**KIRKLEES METROPOLITAN COUNCIL
INVESTMENT & REGENERATION SERVICE**

Reference No: 2017/62/92430/E

Site Address: 20, Thomas Street, Heckmondwike, WF16 0NW

Description: Erection of single storey rear extension and dormers
windows to front and rear

Proposed Front Dormer

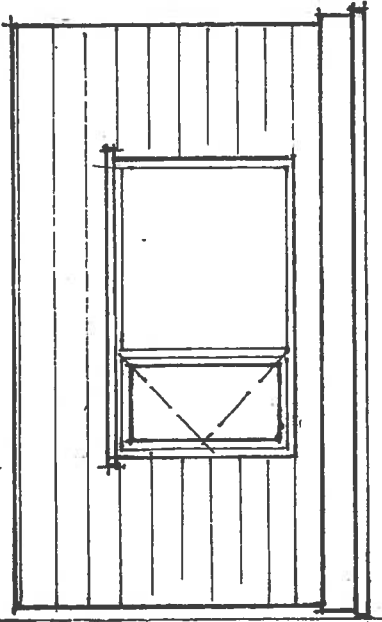
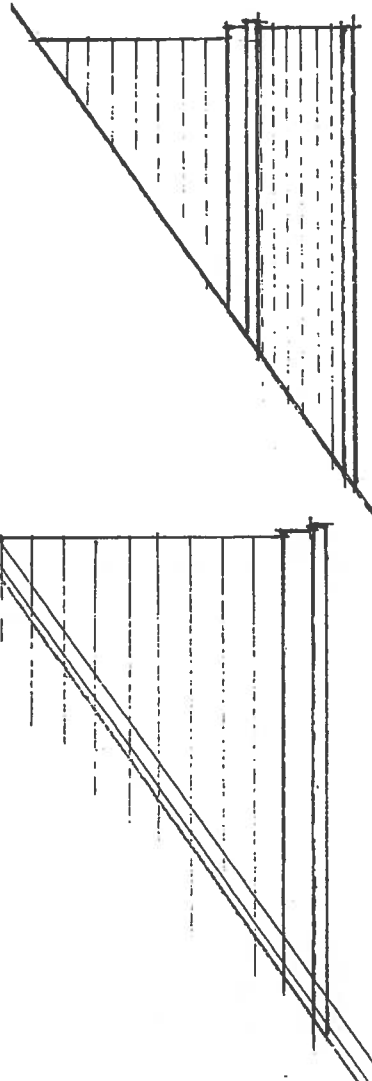
The front dormer has been designed within most of the parameters of Policy BE15. The distance between the top of the dormer and the ridge of the roof has not been achieved; however the design is for a small pitched roof which necessitates the additional height. This is considered to be a preferable design in terms of visual amenity. It is noted that there are no other similar dormers within the row. However, this is not considered to be sufficient to

substantiate a reason for refusal of the proposals as the design and form of the dormer is considered to be acceptable in terms of visual amenity.

PROPOSED REAR ELEVATION

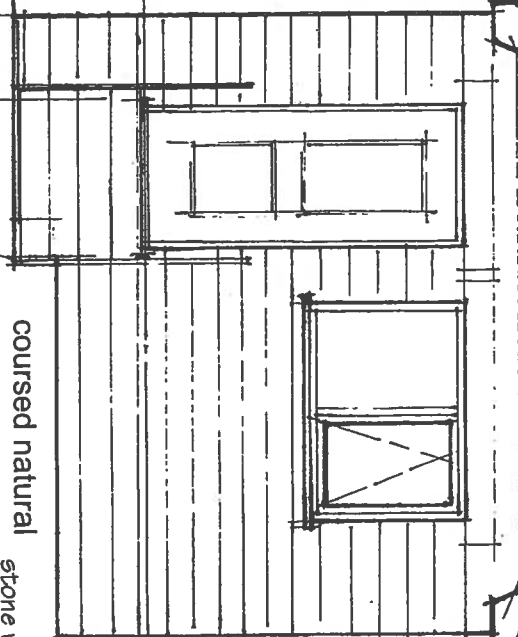
The initially submitted plans were annotated to the effect that the single storey rear extension would be constructed using artificial stone. None of the other properties within this row have been extended and due to a change in levels to the rear, any single storey rear extensions would require planning permission. The use of artificial stone would have the potential to form an awkward relationship with the host property and if others within the row were to apply for similar extensions, this could be damaging to the character of the properties within this row and visual amenity in general. As such, it was considered appropriate to ask for the plans to be amended to show the use of natural stone.

The initial plans detailed the use of artificial stone for the single storey rear extension which would have had the potential to be damaging to the character of the host property and terrace. As such, amended plans were sought and received to amend the detail to show the use of natural stone.
